CITY OF ALBUQUERQUE

November 5, 2019

Re: 3123 Central Ave NE
3123 Central Ave NE
30-Day Temporary Certificate of Occupancy
Transportation Development Final Inspection
Engineer's/Architect's Stamp dated 3-1-19 (K16D201)
Certification dated 10-30-19

TCL

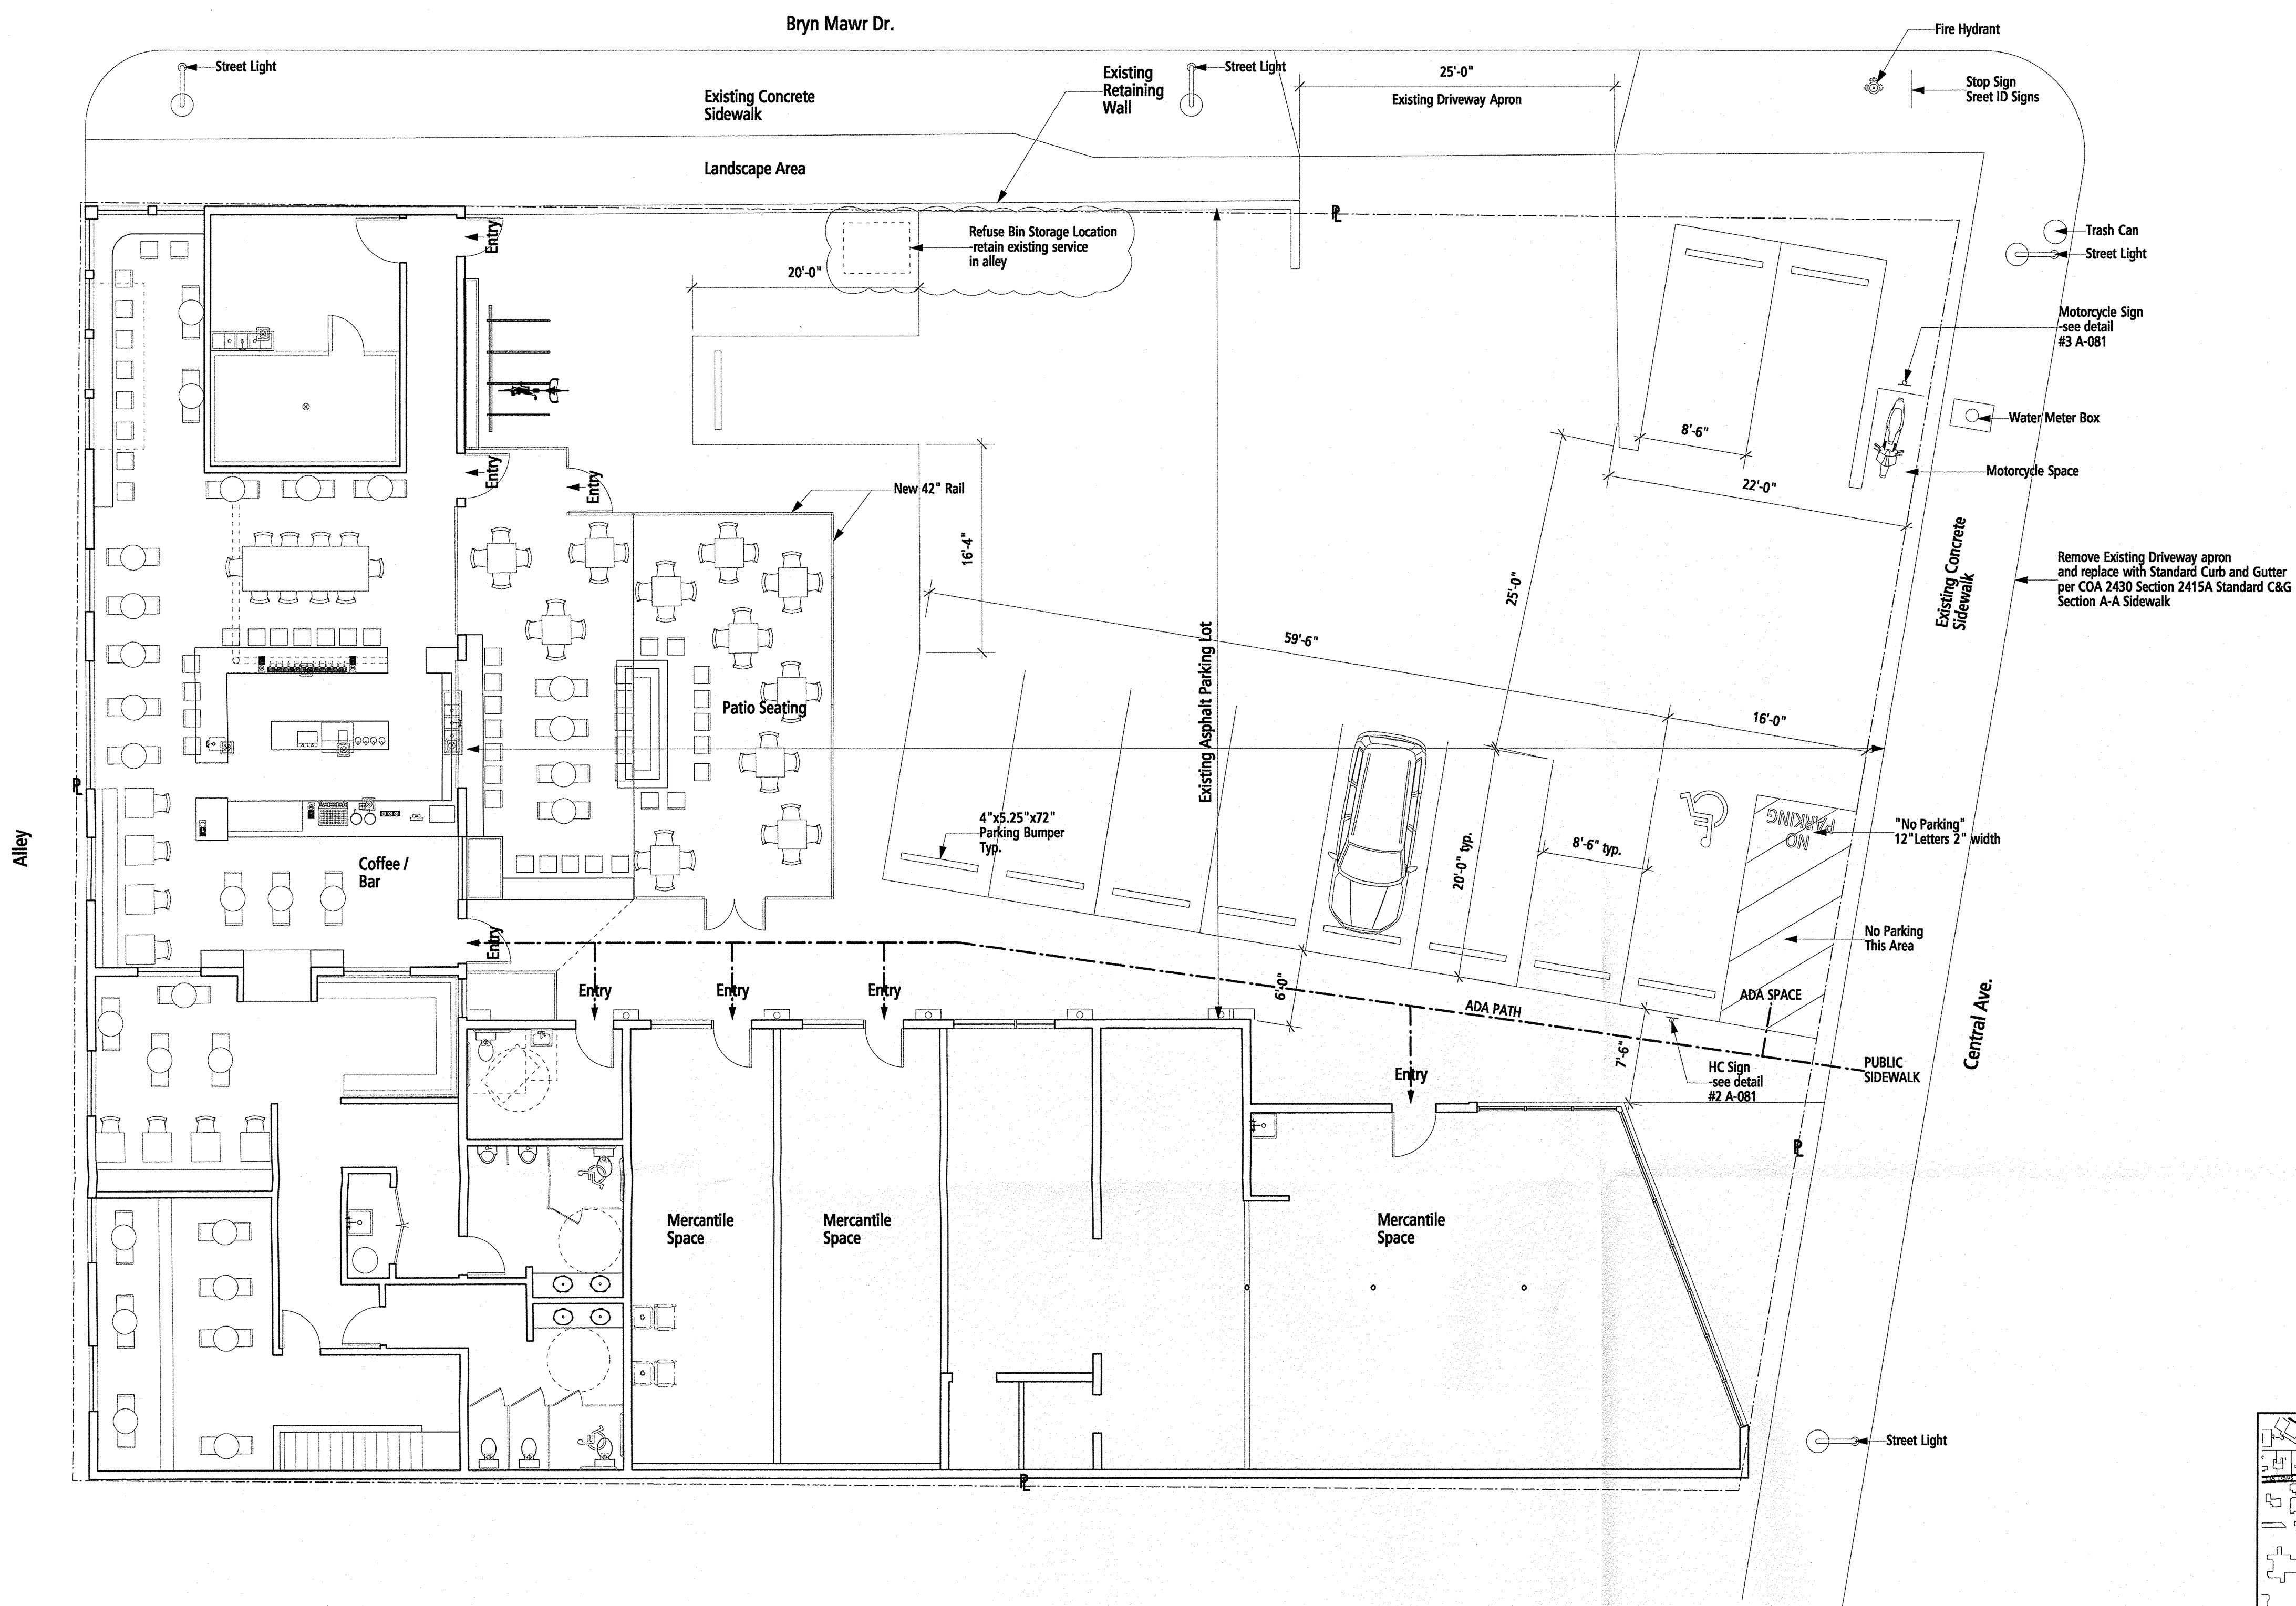
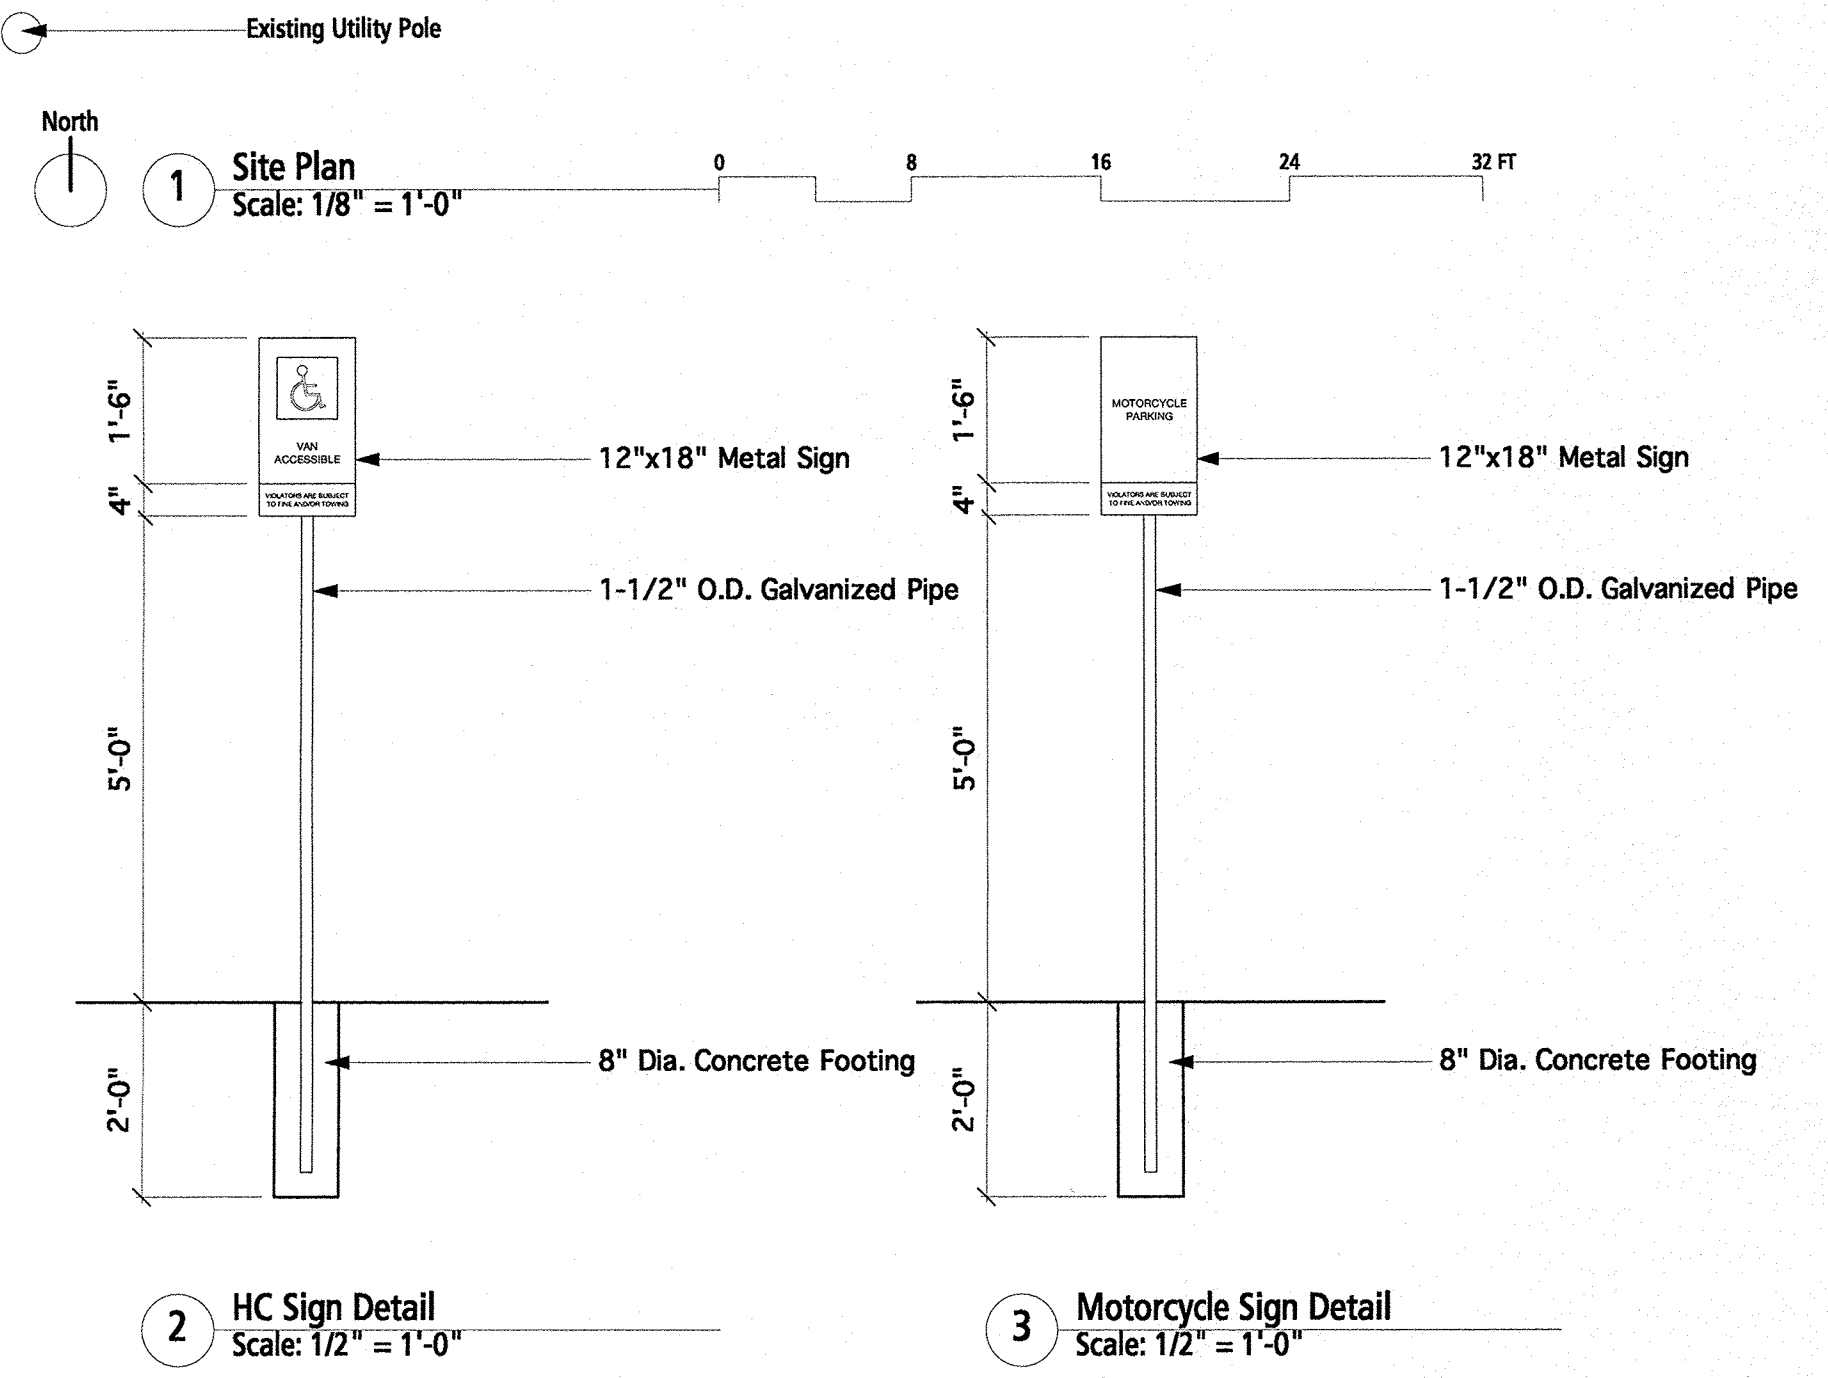
- Please replace existing drive with Sidewalk, Curb and Gutter.
- Please add No Parking to the ADA Access Aisle
- Please remove Construction debris and material.
